1. Land Use Planning

Council Submission Recommendation (November 2021)	Response to Submissions Report (April 2022)	Council Comments (June 2022)	Response to Request for Further Information (December 2022)	Council Comments (February 2023)	Response

DRAWING TITLE
SOLAR ACCESS
DIAGRAMS - WINTER
SOLSTICE

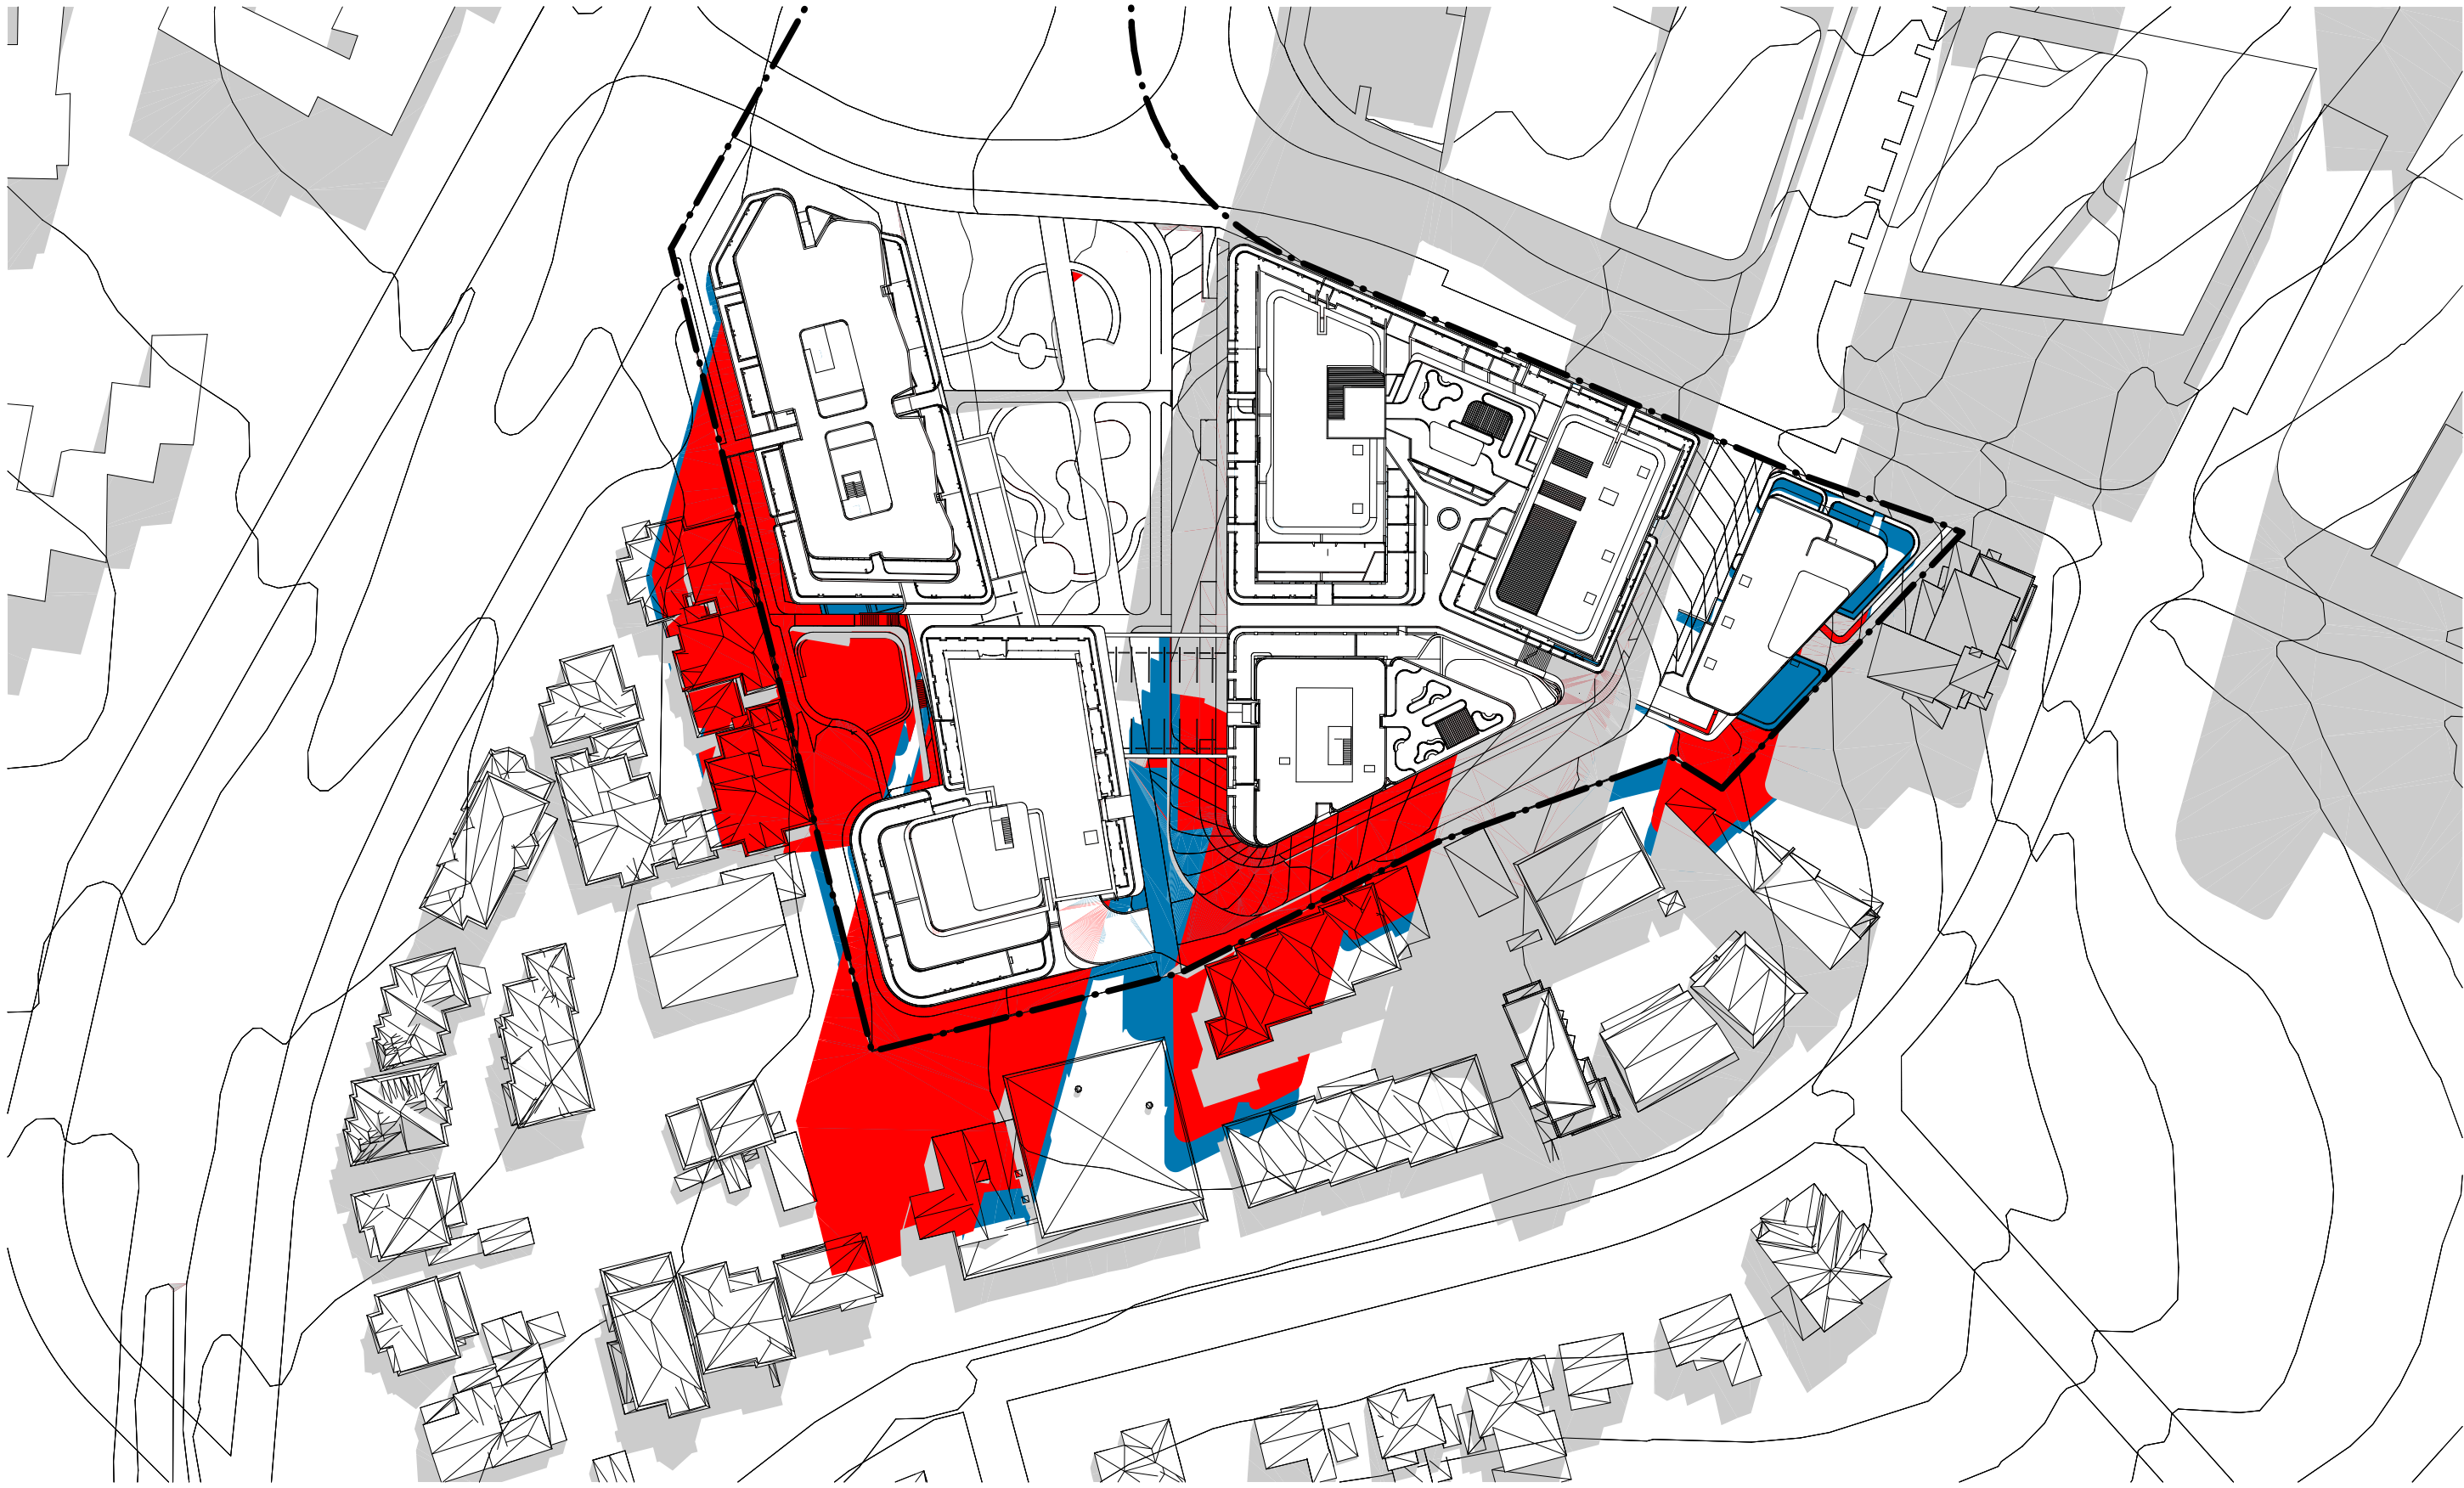
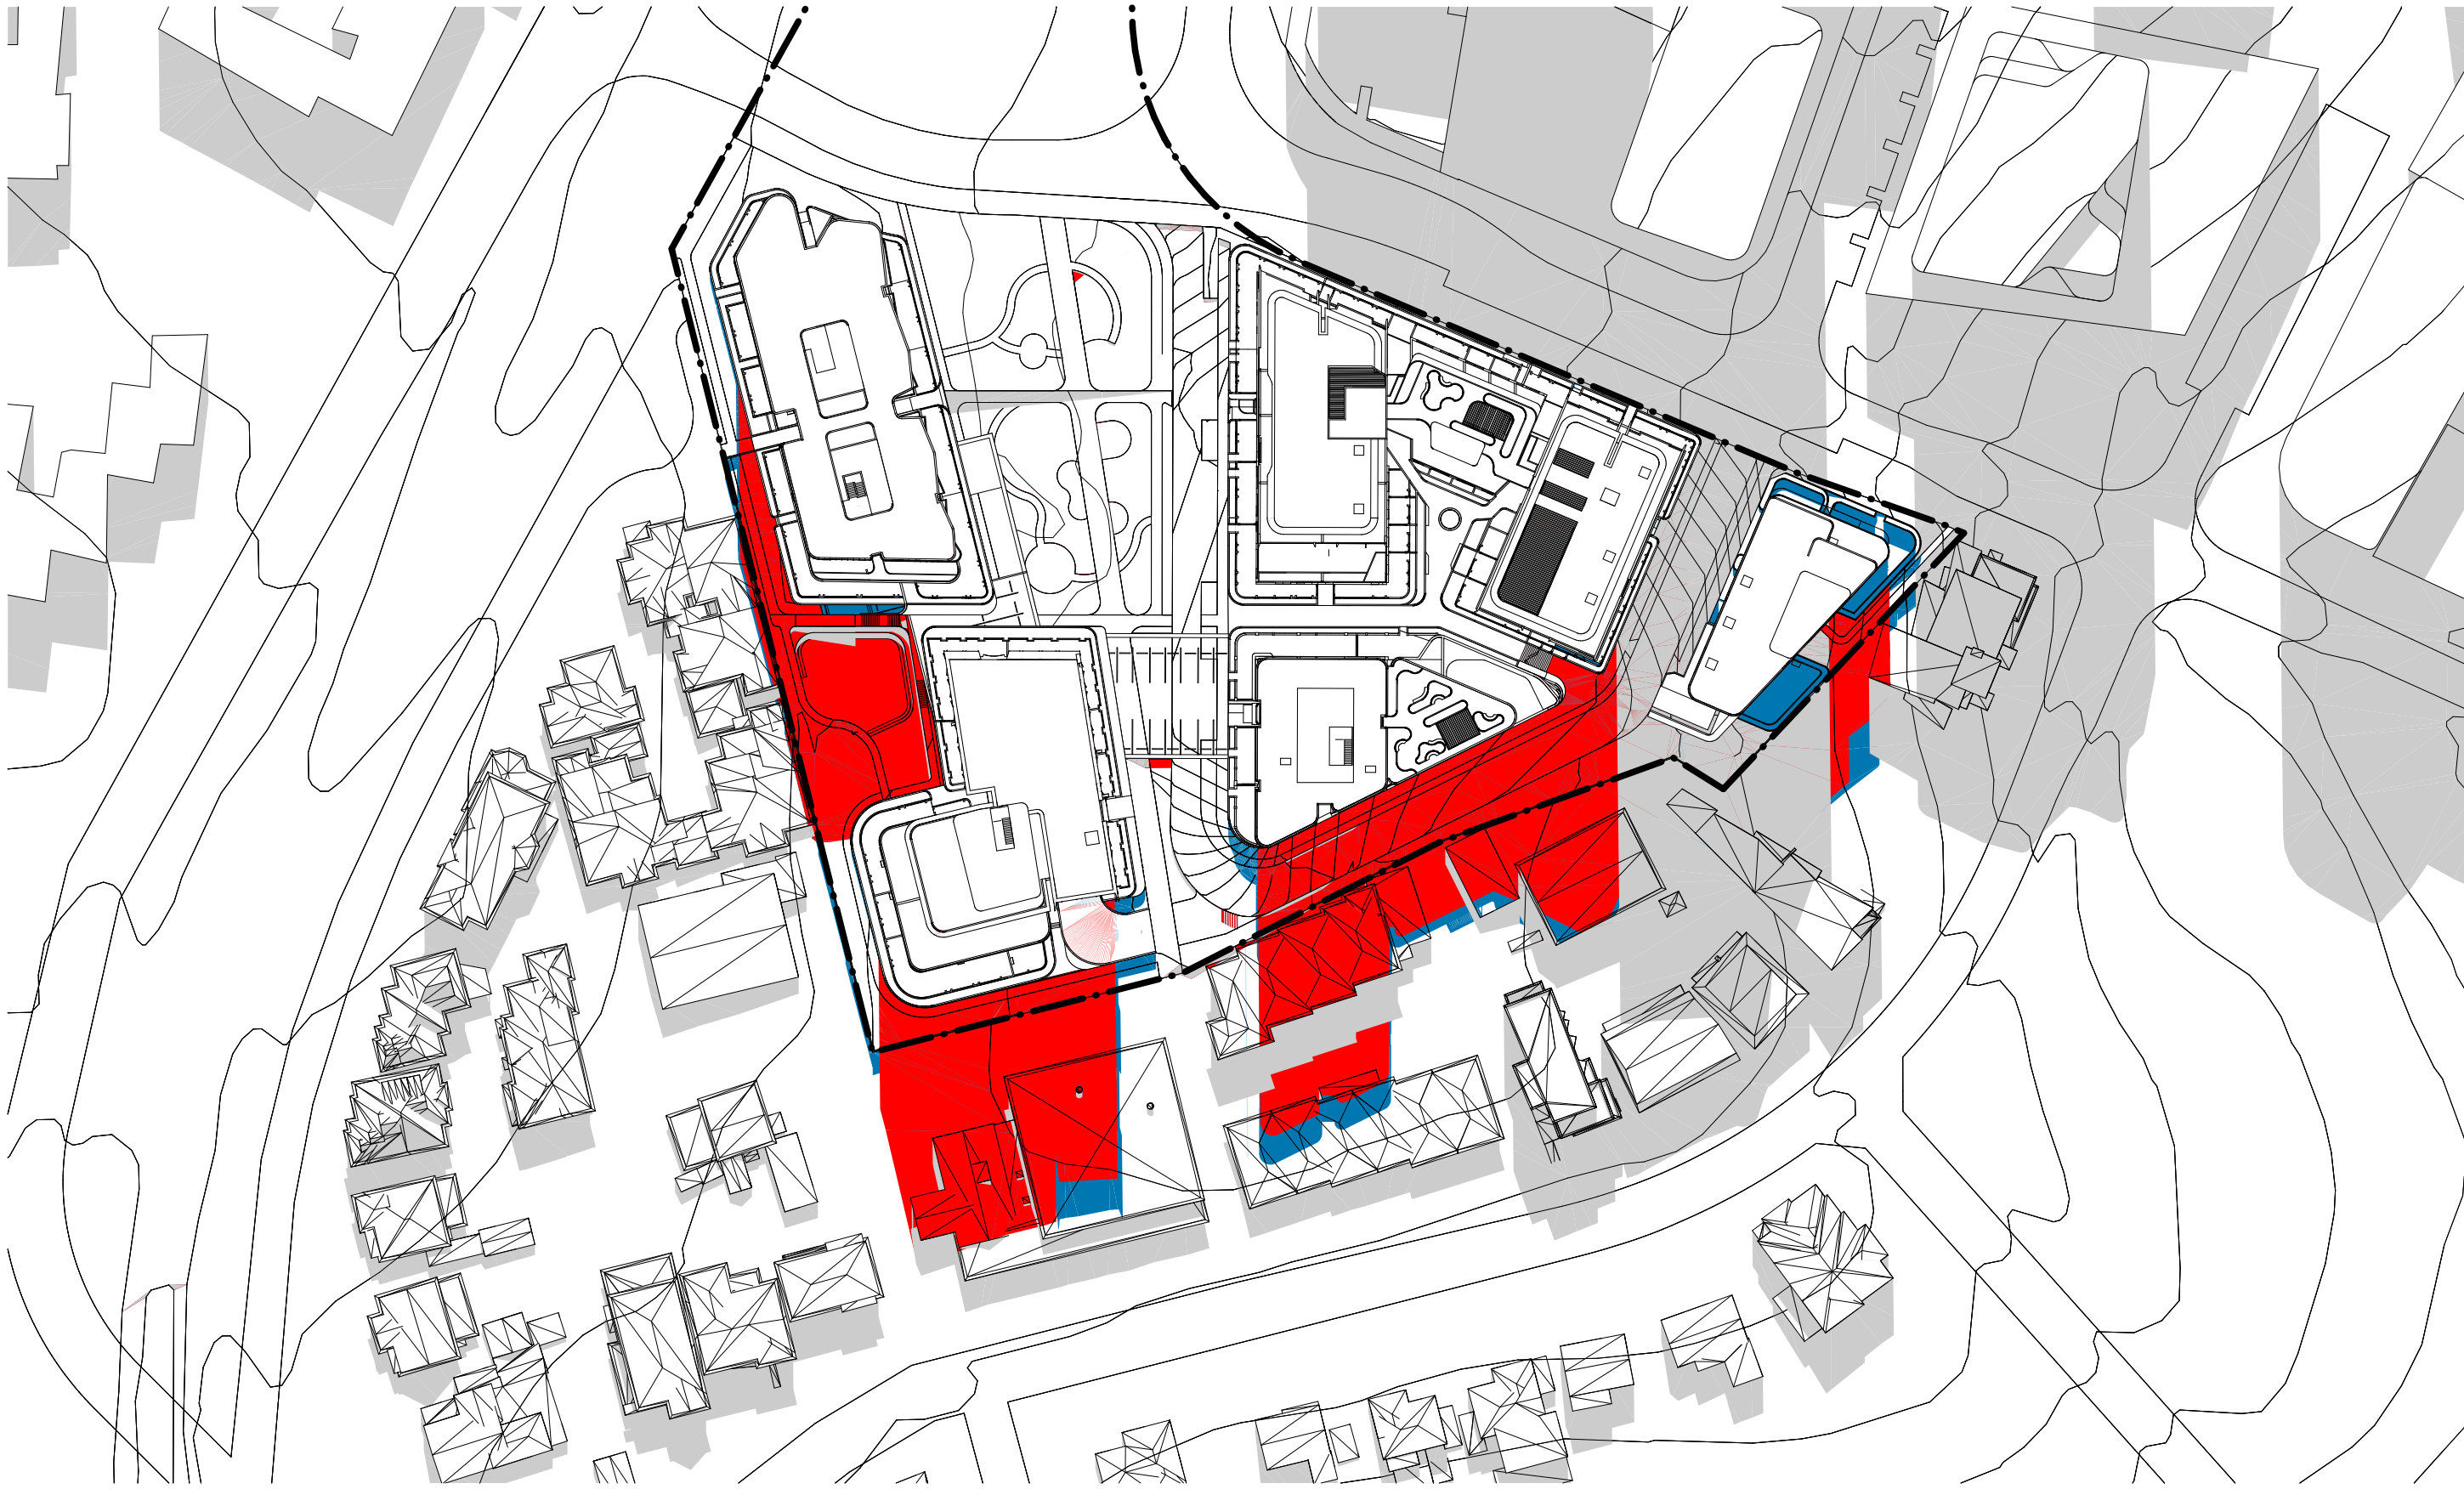
<i>Solar Analysis:</i> Solar analysis centres on the number of hours of sun access to spaces but does not consider the time of day these spaces may receive additional	Solar access shadow diagrams have been prepared by Bates Smart and are included in the Design Concept Plan Report. Shadow diagrams have been prepared for hourly intervals from 9am	<p>Solar analysis must clarify the difference between a 'Proposed Envelope' and an 'Indicative Design Scheme.'</p> <ul style="list-style-type: none"> • The following buildings must comply 	Refer to ADG Summary for Concept Works prepared by Bates Smart (Appendix C of RFI Letter) which confirms 70% of apartments in N6.1 and 72.1% of

overshadowing from the proposed buildings. Hourly solar diagrams should be provided for each open space to assess when overshadowing may be happening (i.e., if there is additional overshadowing during the lunch period this is a concern).	to 3pm for 21st June, representing the greatest overshadowing impact through the year. The shadow diagrams compare the shadow cast by existing development at the site, shadow cast by a building height compliant with the PLEP 2011, shadow cast by the proposed Concept Approval building envelopes, and shadow cast by the reference scheme.	with the minimum ADG requirements for solar access (75% of apartments) – N6.1 and S5. • The following buildings must comply with the maximum ADG requirement for no sun (7% of apartments) – N7.2, N9.1a, N9.1b, S2, S7, S8. Reconsider building C6.1c which does not result in enough apartments receiving the minimum solar access and exceeds the maximum number of apartments that can receive no sun.	apartments in S5 achieve two or more hours of direct solar access to primary living areas and private open spaces between 9am to 3pm in mid-winter in accordance with Objective 4A of the ADG. Refer to Section 2.3 of the RFI
